Project #: 1010140 Application #: 14DRB-70224  
 Project Name: Lands of Ted Jorgensen & Celis Industrial Subd 2  
 Agent: Cortesian Stouffs Inc. Phone #:

**CITY OF ALBUQUERQUE  
PLANNING DEPARTMENT  
July 9, 2014  
DRB Comments**

**PROJECT # 1010140          APPLICATION # 14-70224**

**RE: Lot A. Lands of Ted Jorgensen & Tract P, Cole's Industrial  
Subdivision**

**Plat for
 Lot A-1, Lands of Ted Jorgensen**

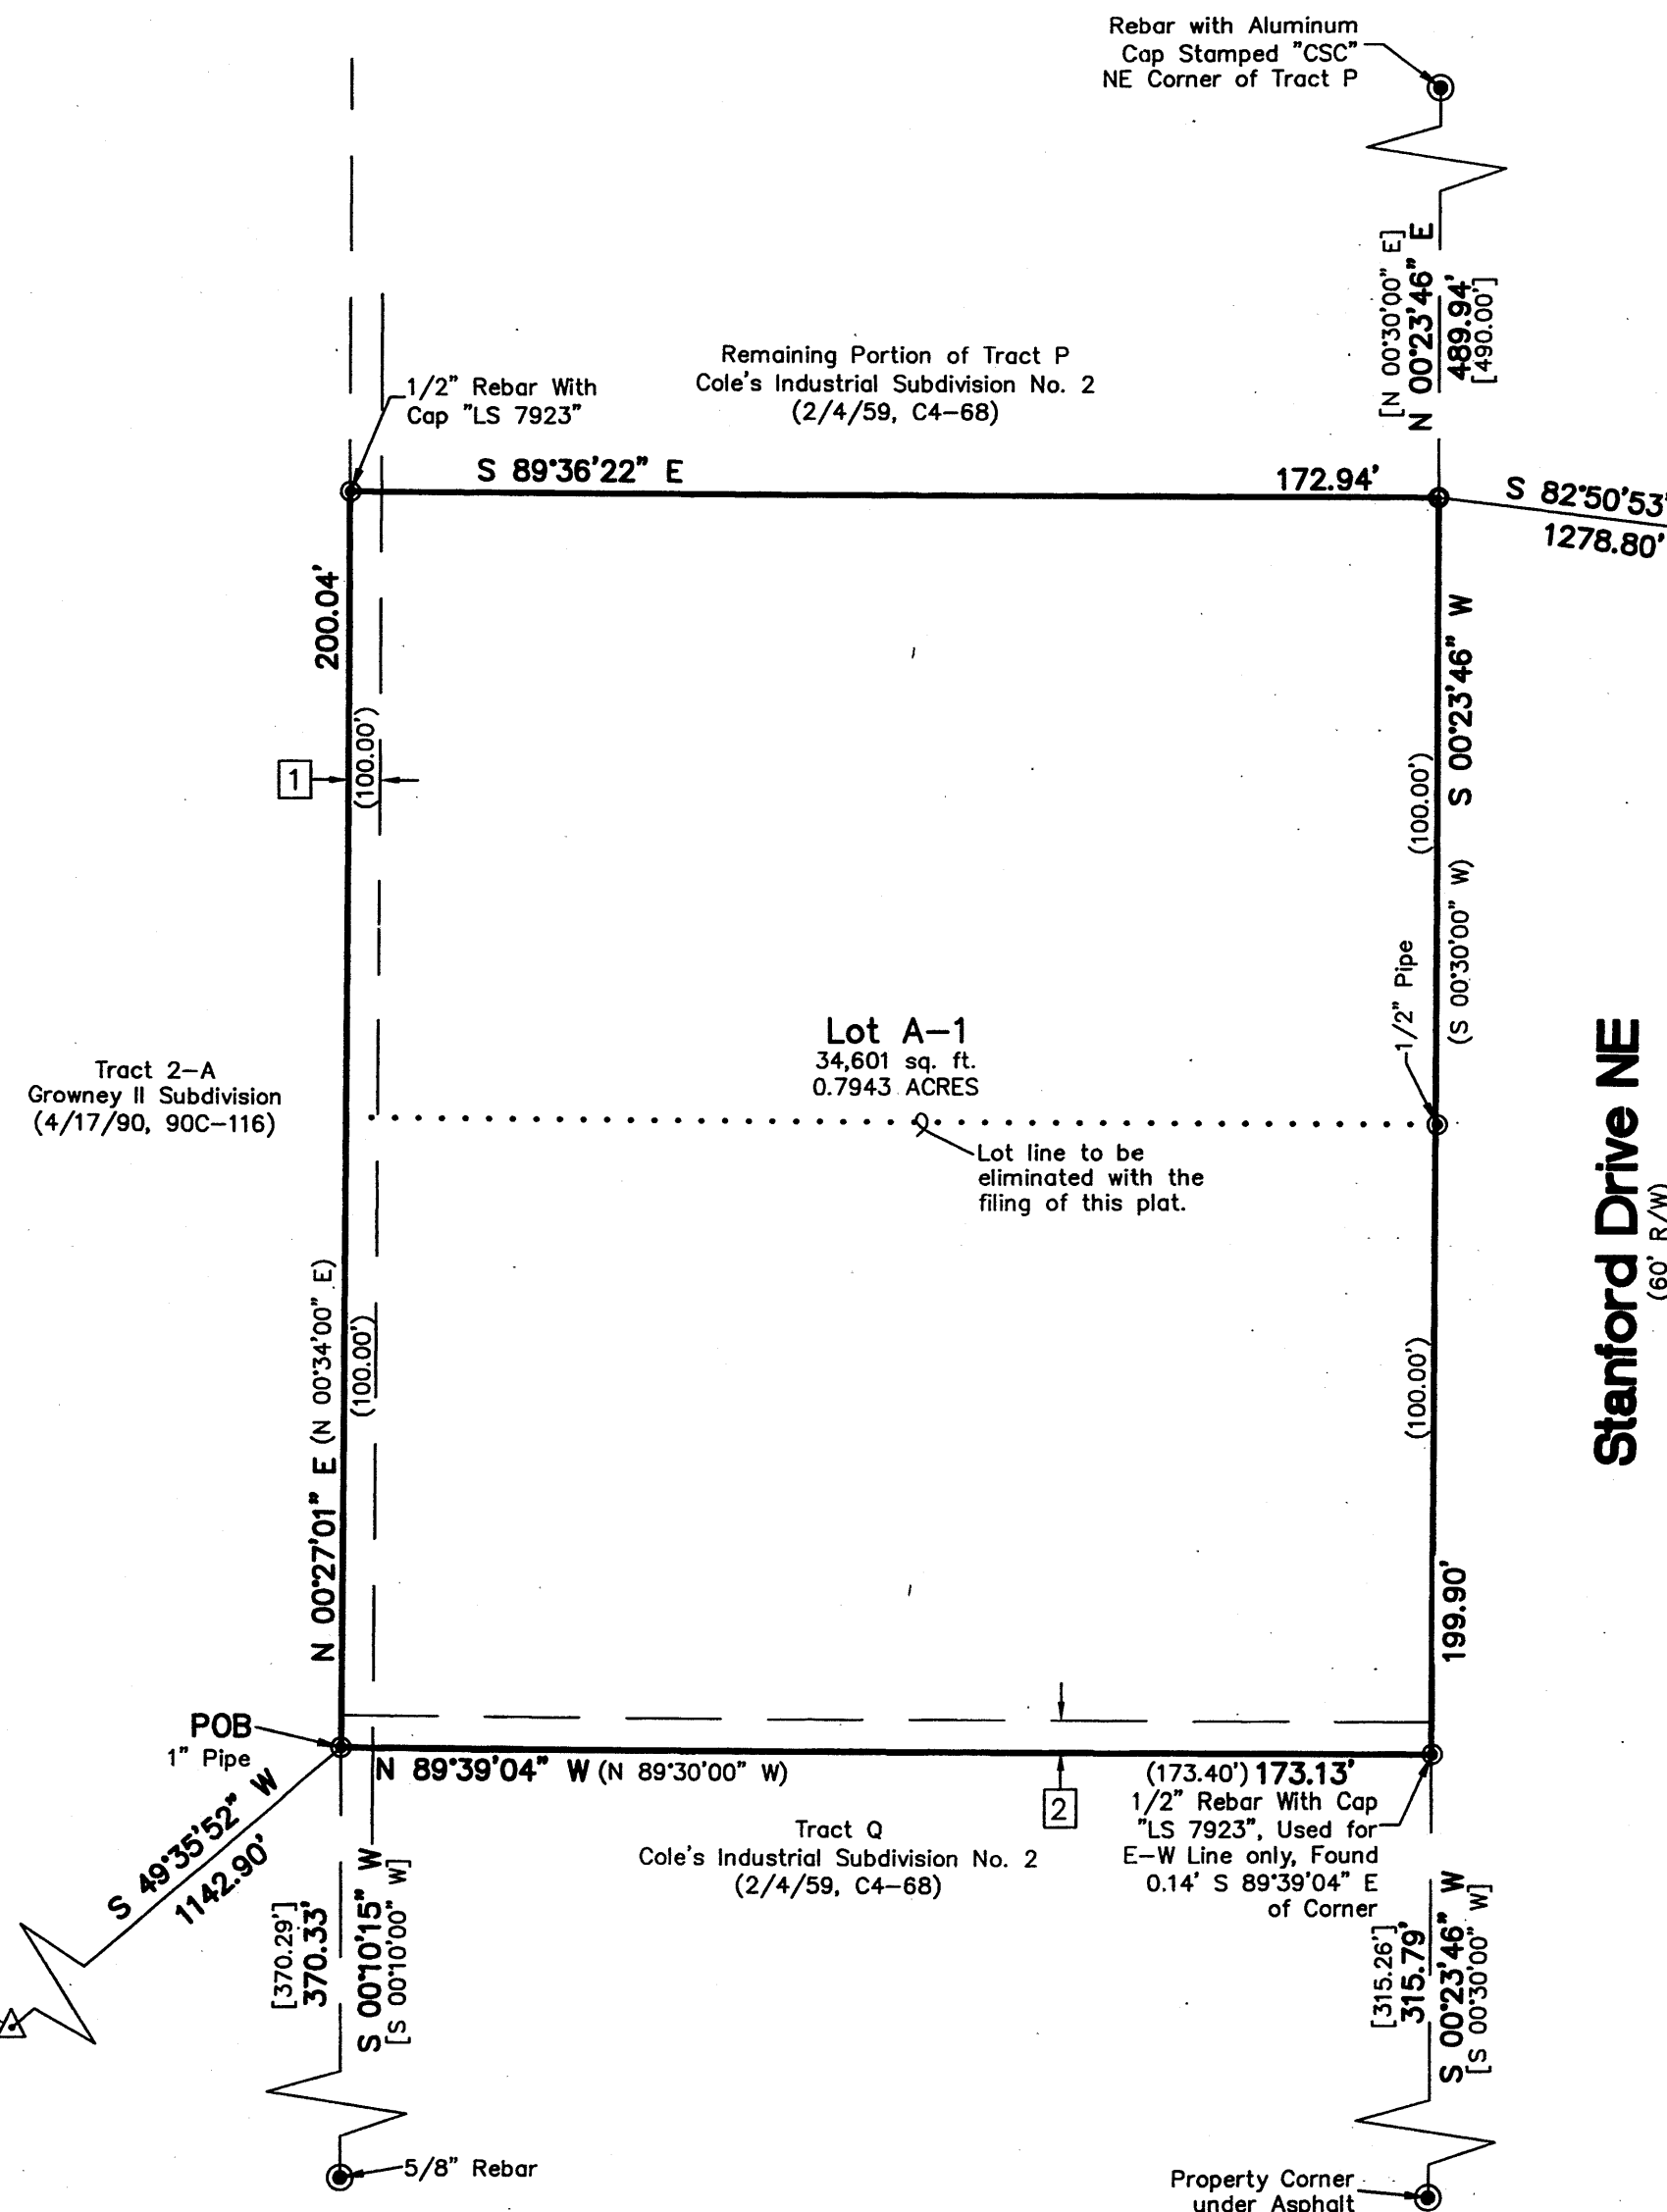
“Portions of” Tract P must be documented prior to the current (1973) version of the Subdivision Ordinance and referenced on the plat, otherwise all of remaining Tract P must be included in the proposed subdivision.
